Our reference: DOC17/492572

EPA comments - Development Application SSD 8200
Proposed St Marys Resource Recovery Facility at 21 & 25 Dunheved Circuits

ATTACHMENT A

Figure 1-1: The Proposal site layout

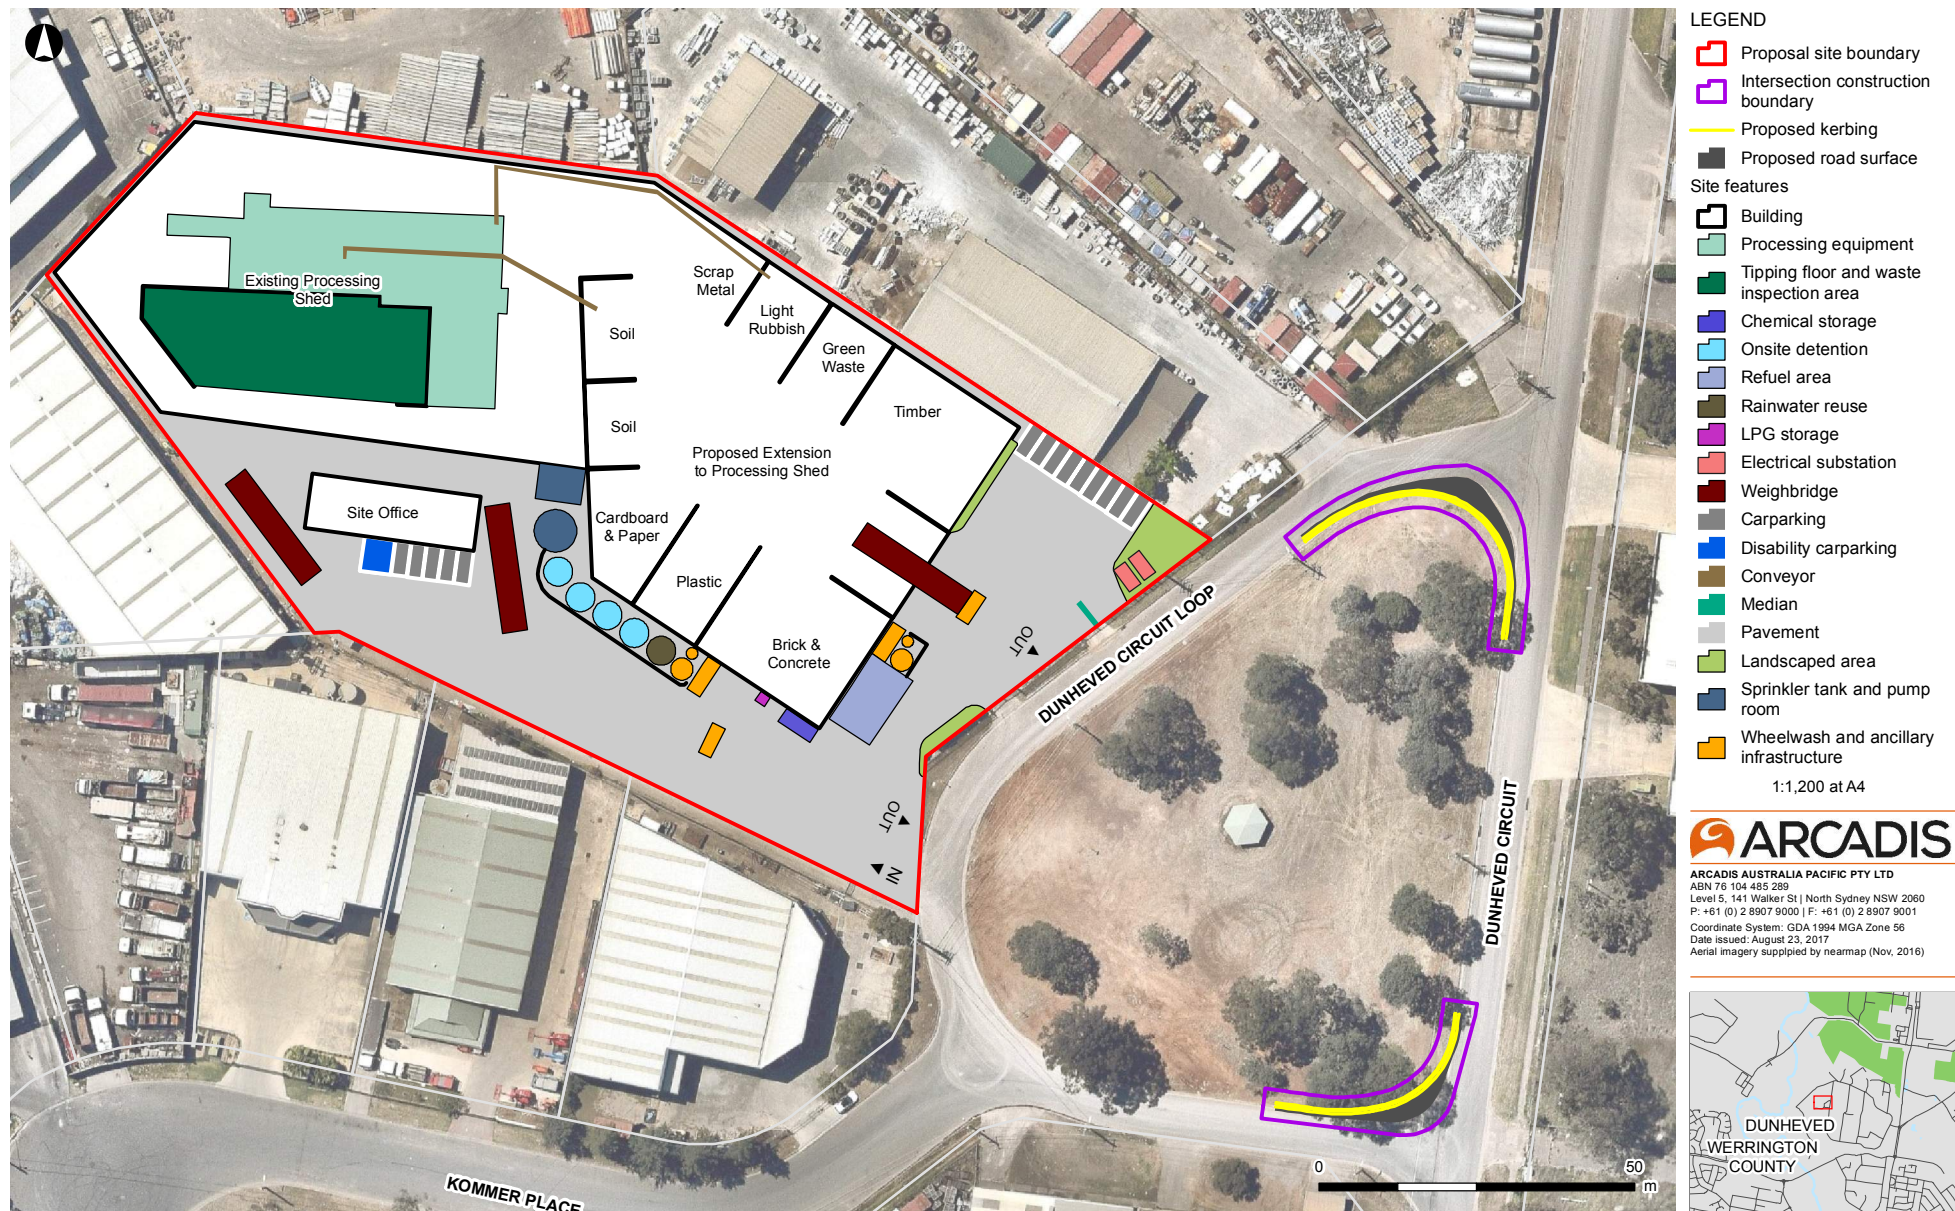
implemented, as different commitments are made in different sections of the EIS. For example, Section 4.2.7 of the EIS states that stormwater will be captured in four OSD tanks, and these tanks are shown on the site layout diagram (Figure 1-1) and the stormwater drainage plan (Appendix G). However, Section 9.4, Table 17-1 and Appendix N make no mention of the OSD tanks and state instead that stormwater will be managed through a filtration device, gross pollutant traps, pit inserts, bioretention basins and storm-filters. These controls are not shown on the site layout diagram, or on the stormwater drainage plan.

The EPA requires the Proponent to provide a schematic diagram indicating the locations of each stormwater control and the direction of roof water, surface water and underground stormwater flows across the entire Premises (not just 21 Dunheved Circuit).
